Subject: RE: Planning Consultation on: BE/82/21/PL

Please see Private Sector Housing comments, below. These comments are in relation to general housing conditions and have regard to the Housing Act 2004, Housing Health and Safety Rating System (England) Regulations 2005 and LACoRS national fire safety guidance.

Description of Works: 1 No. 2-bed & 2 No. 1-bed flats above shop premises to rear of Truevision.
This site is in CIL Zone 4 (Zero Rated) as flats.

E & N Elevations

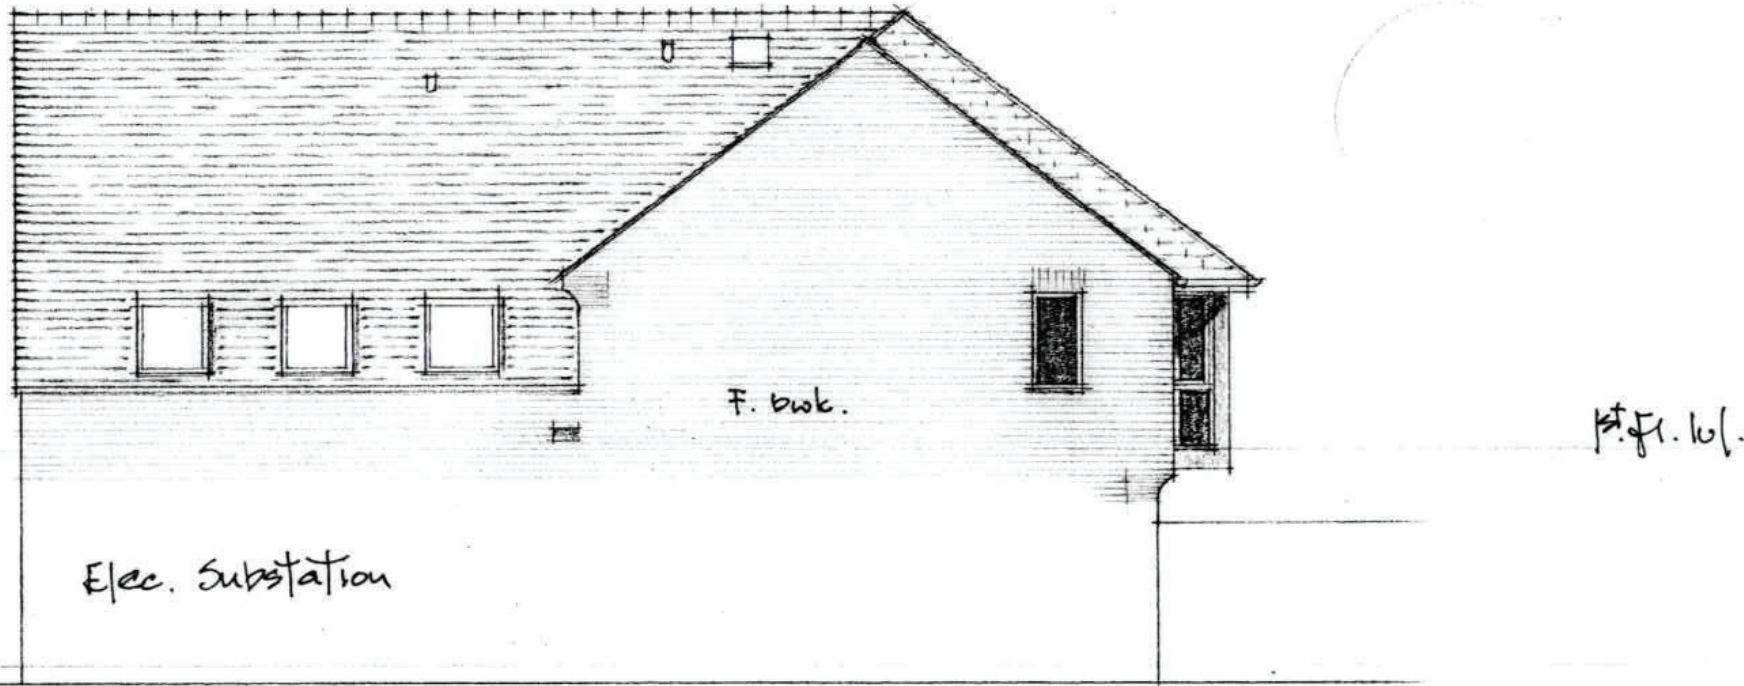
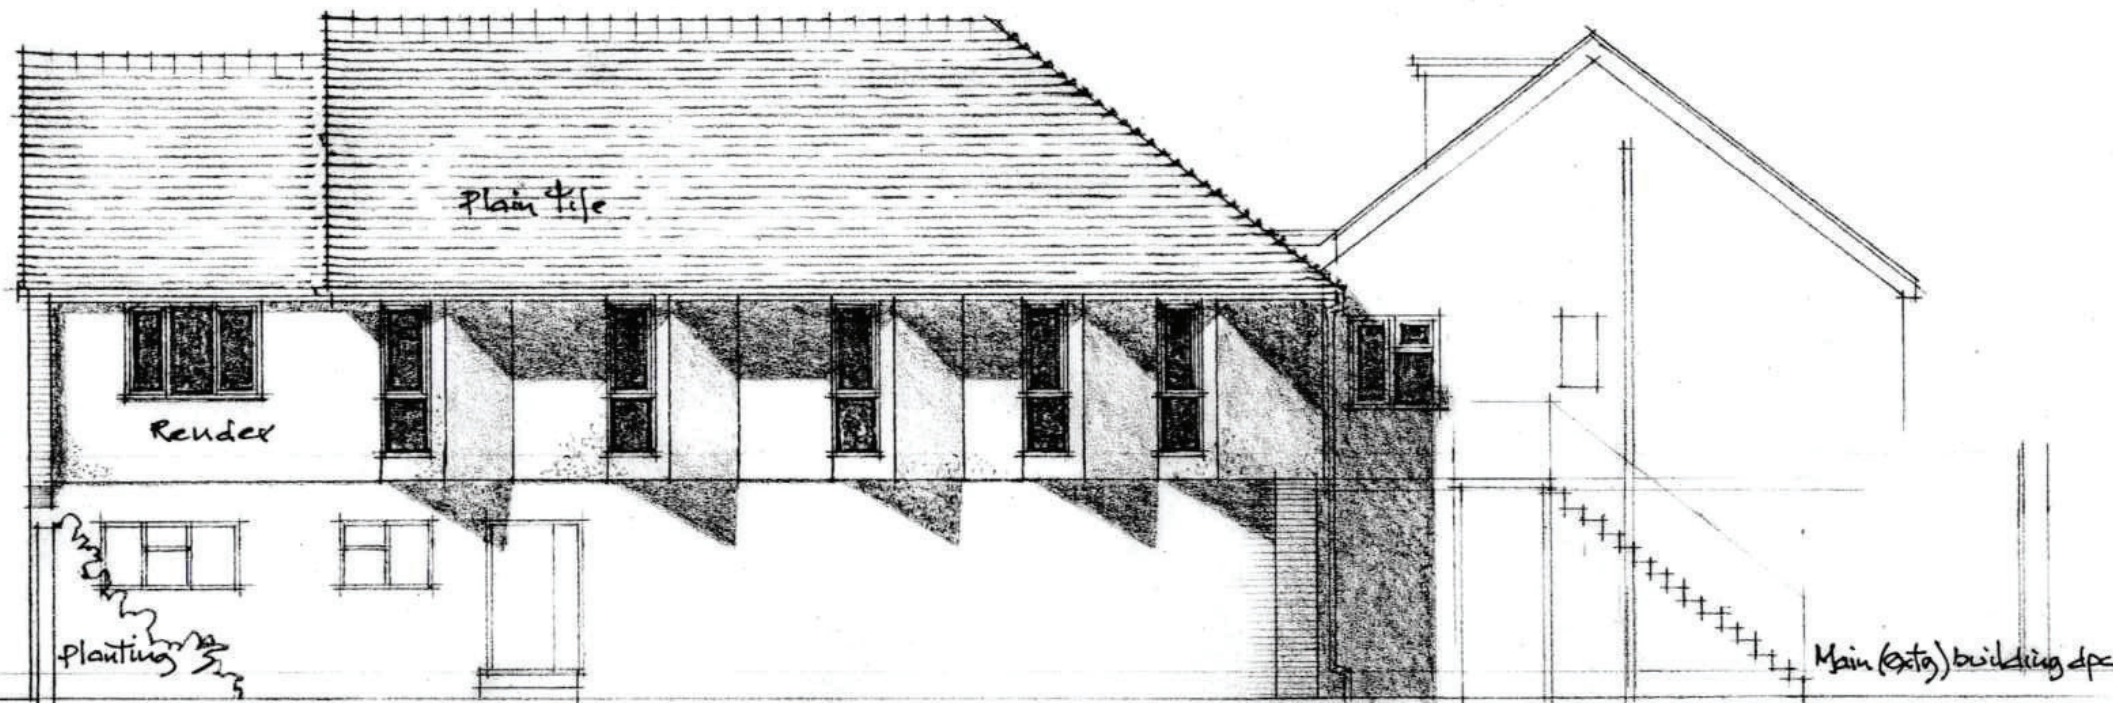
- The window casements to the North aspect, notably the sitting room and both bedrooms to flat 1 and the bedroom to flat 2, appear to be on the smaller side. Window casements should provide a minimum openable area equivalent to 1/20th of the total floor area within that room
- Opening limiters should be installed to all windows above the ground floor to prevent windows being opened more than 100mm. Opening limiters should not be key operated
- The roof windows serving the sitting room in flat 3 should be of an appropriate height and angle to provide a reasonable view outside of the immediate surroundings
